C18D101

Project Title: SILVER OAK SUBDIVISION lot 6 Building Permit #: _____ City Drainage #: C18D101
DRB#: 1010644 EPC#: _____ Work Order#: _____
Legal Description: SILVER OAKS
City Address: 8815 SILVER OAK

**RE: Drainage Resubmittal
Silver Oak Subdivision- (C18D101)
Albuquerque, New Mexico**

RE: Silver Oak Estates | Grading and Drainage Plan | Stamp 10-21-15 (File: C18D101)

SILVER OAK ESTATES MASTER PAVING PLAN	
DATE 12-11-15	BY WCM
SHEET # 5	JOB # 21525-LAYOUT-9-21-15
Rico Grande Engineering 1808 CENTRAL AVENUE SE SUNTEC 501 ALBUQUERQUE, NM 87106 (505) 872-0999	
P.E. #14522 DAVID SOULE

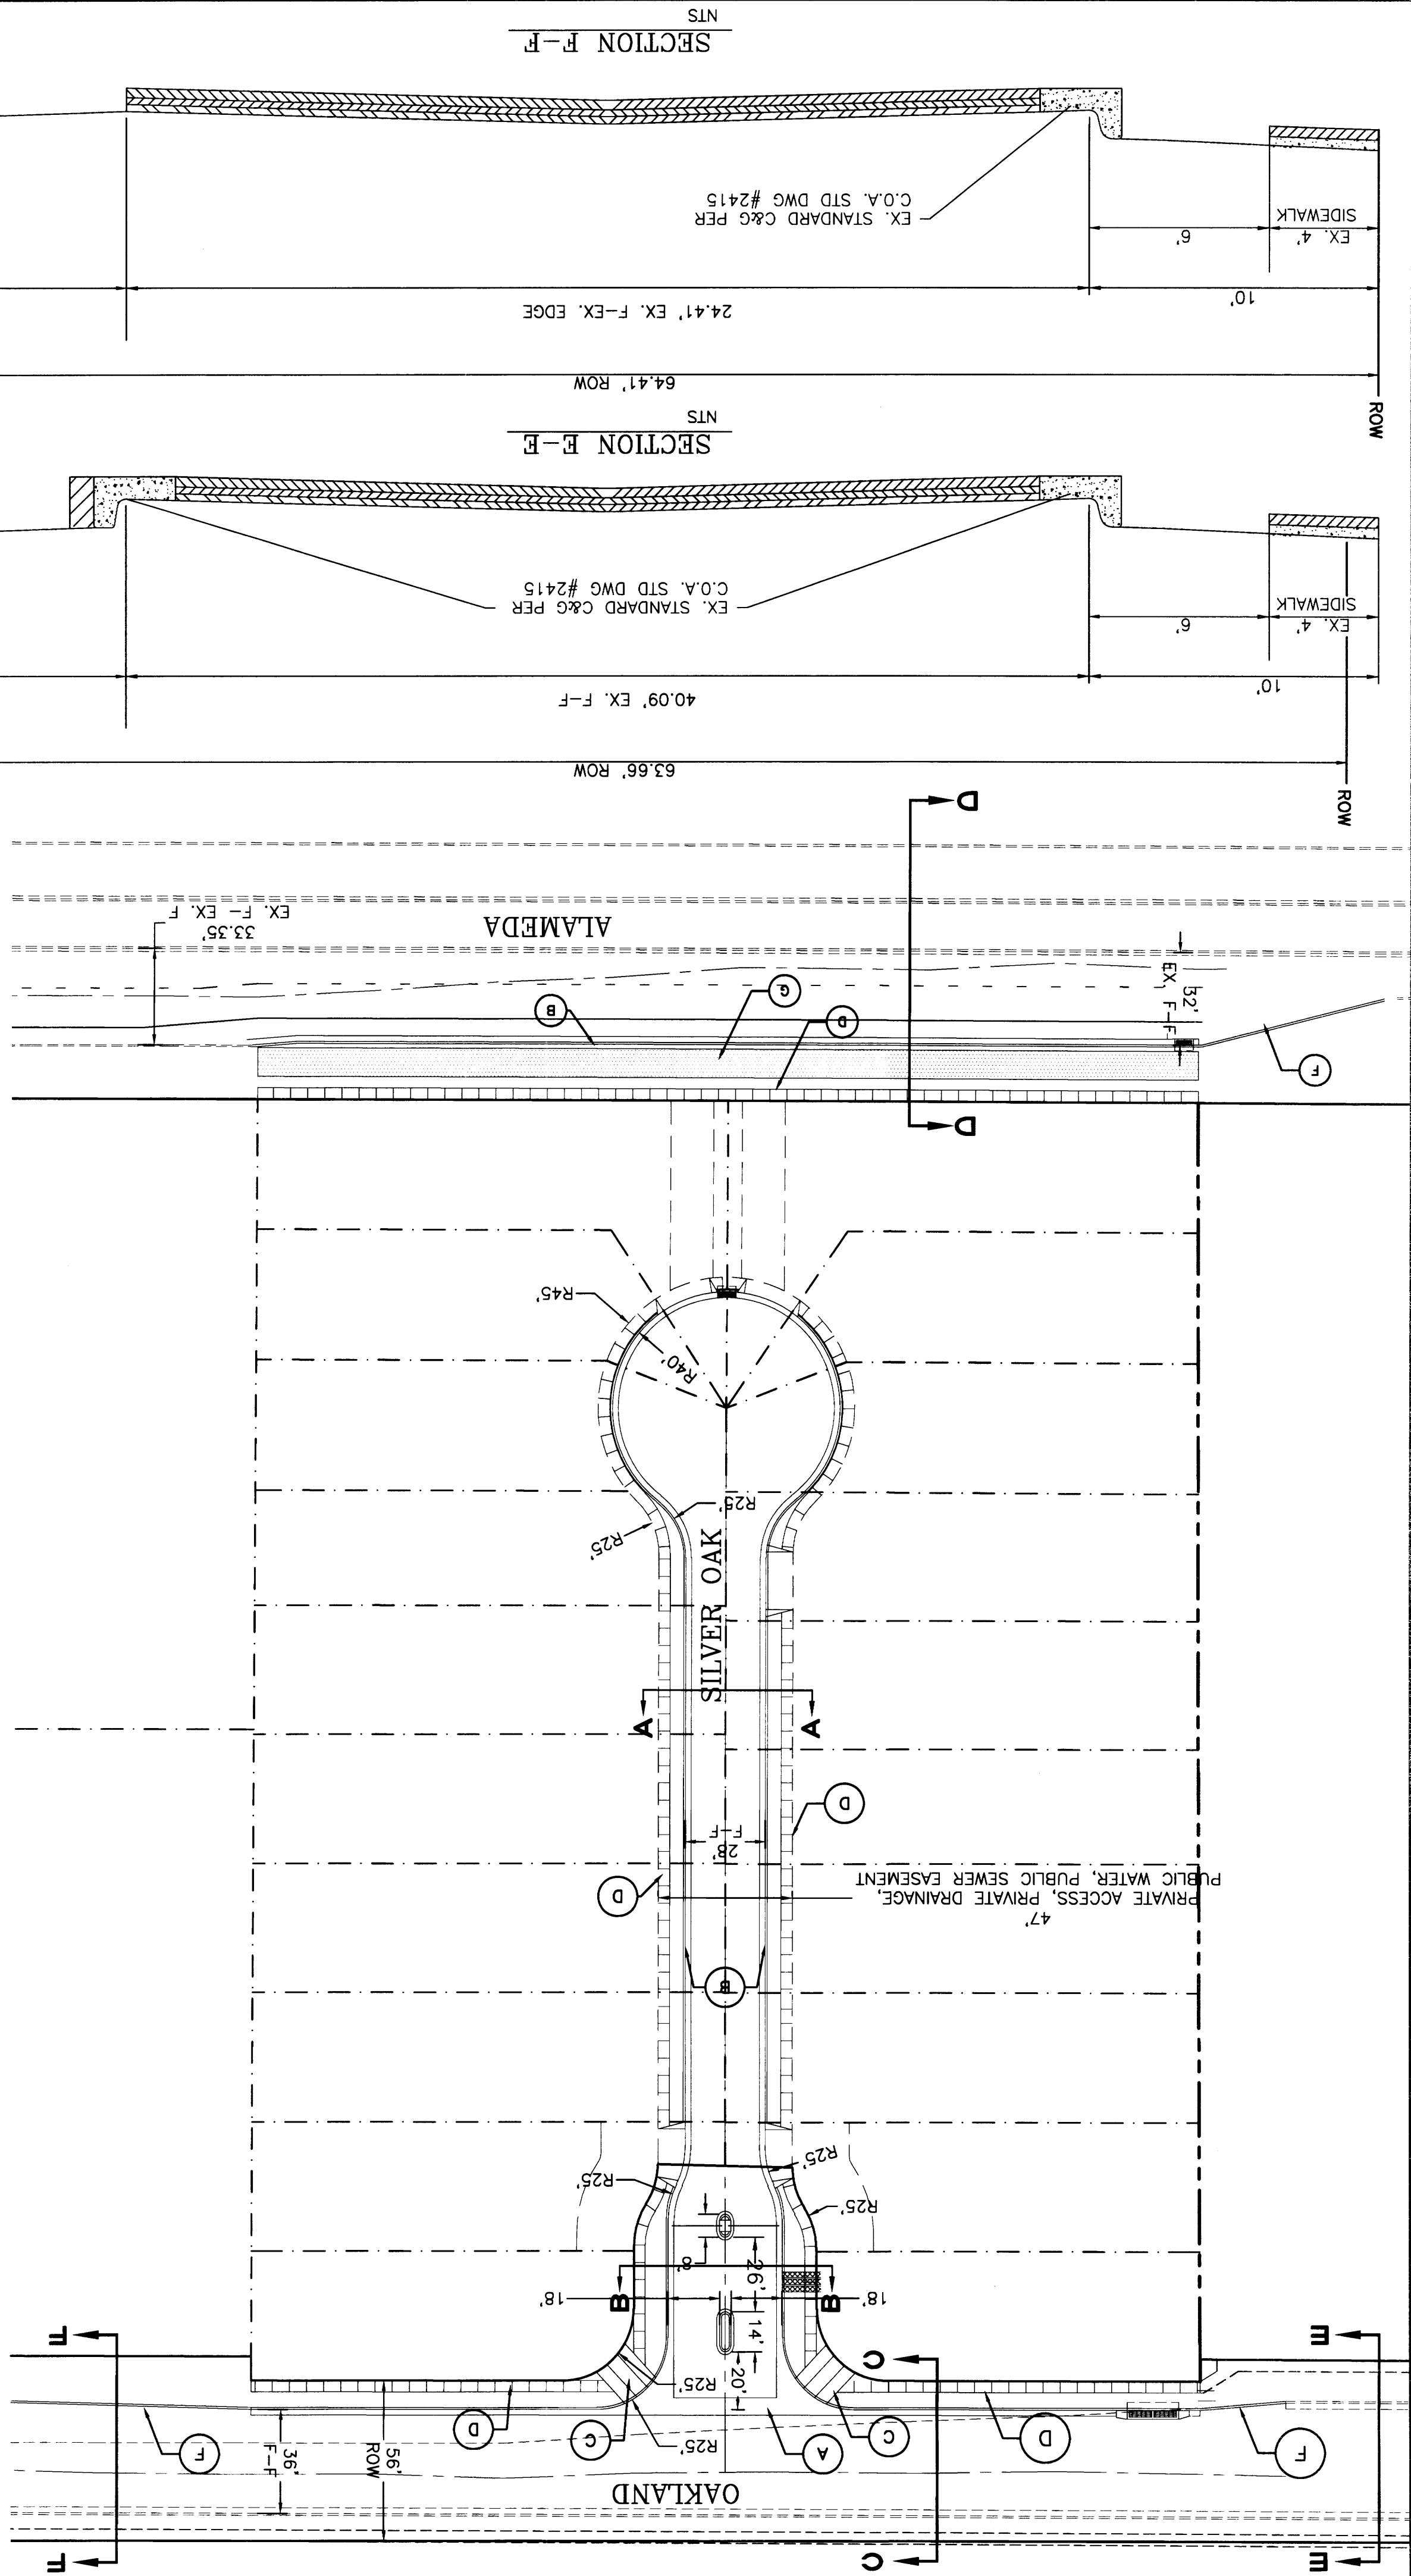
1. Clarify the easement dimensions between the cul-de-sac and Alameda Blvd. The Utility Plan shows a different layout than the Site/Grading Plan.
2. The inlet at the end of the cul-de-sac bulb appears to conflict with the intent to have an access easement to the southernmost lots.

4. The inlets on Oakland and Alameda should have build notes
 - a. The inlet on Alameda is referenced as a single grate Type D inlet to capture flows at the flowline of the roadside swale, but shown differently on the plan. Furthermore, this inlet and pipe needs to be planned with the future expanded section of Alameda Blvd in mind.

2. The inlet at the cul-de-sac conflicts with access to southern lots
We have reduced the inlet to a single A, the inlet is in sump and has double the capacity. This inlet calculation has been included. We have shown the driveways to confirm the geometry

4. Inlets in Oakland and Alameda shall have build notes. The plans and report need to be consistent. The location needs to account for Alameda ultimate section
We have added the build notes and corrected plan to conform to the report. The proposed inlet in Alameda is being placed where an existing stub was constructed. The inlet is being placed at the ultimate curb location.
